# DRB CASE ACTION LOG (Preliminary / Final)

DRB Application No.: 09DRB-70065 Project # 1001880  
 Project Name: Reynaud Addition  
 Agent: Wayjohn Surveying Phone No.: 255-2052

RE: Minor Preliminary/Final Plat of Lot 11-A, Block 2, Reynaud Addition (Project No. 1001880)

EXISTING CONDITIONS

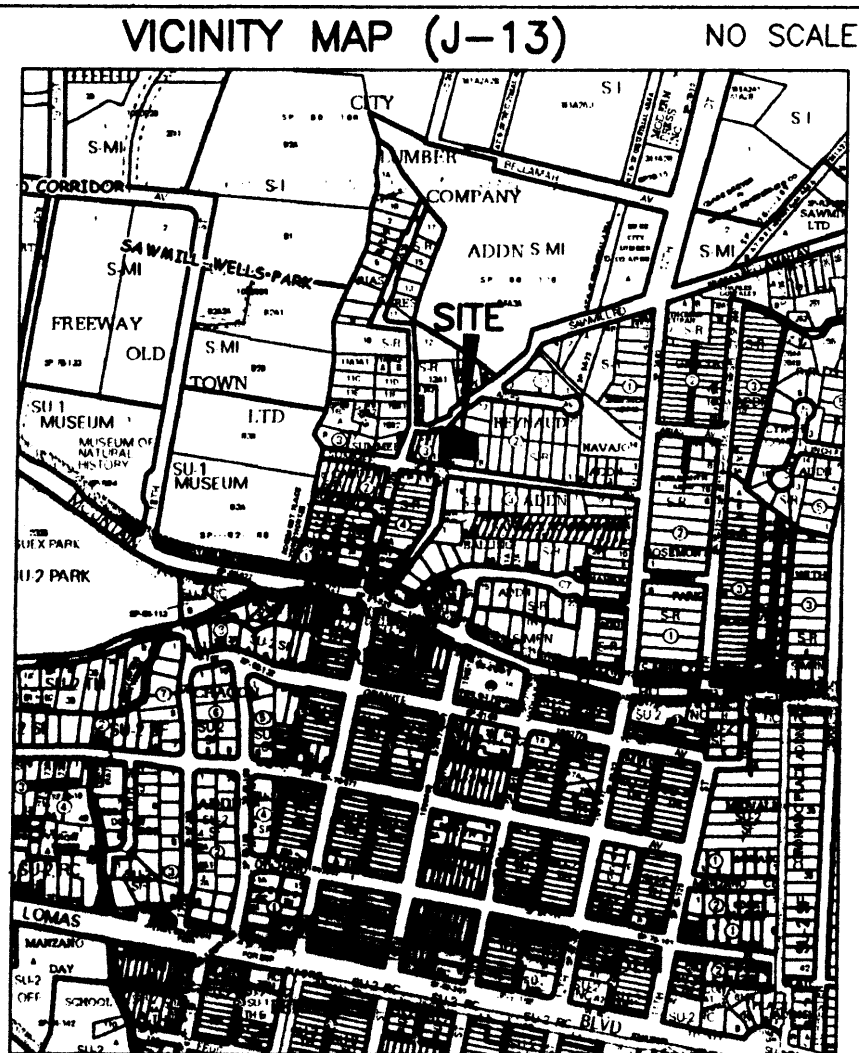
TRANSPORTATION: - show fence removal

WAYJOHN SURVEYING INC agent(s) for JOHN DEERING/LAWRENCE SCHULTZ request(s) the above action(s) for all or a portion of Lot(s) 10 & 11, Block(s) 2, **REYNAUD ADDITION** zoned S-R, located on SAWMILL RD NW BETWEEN 12TH ST NW AND MONTAÑO RD NW containing approximately .219 acre(s). (J-13) **THE PRELIMINARY/FINAL PLAT WAS APPROVED WITH FINAL SIGN OFF DELEGATED TO TRANSPORTATION FOR EXHIBIT INDICATING FENCE REMOVAL AND TO PLANNING FOR AGIS DXF.**
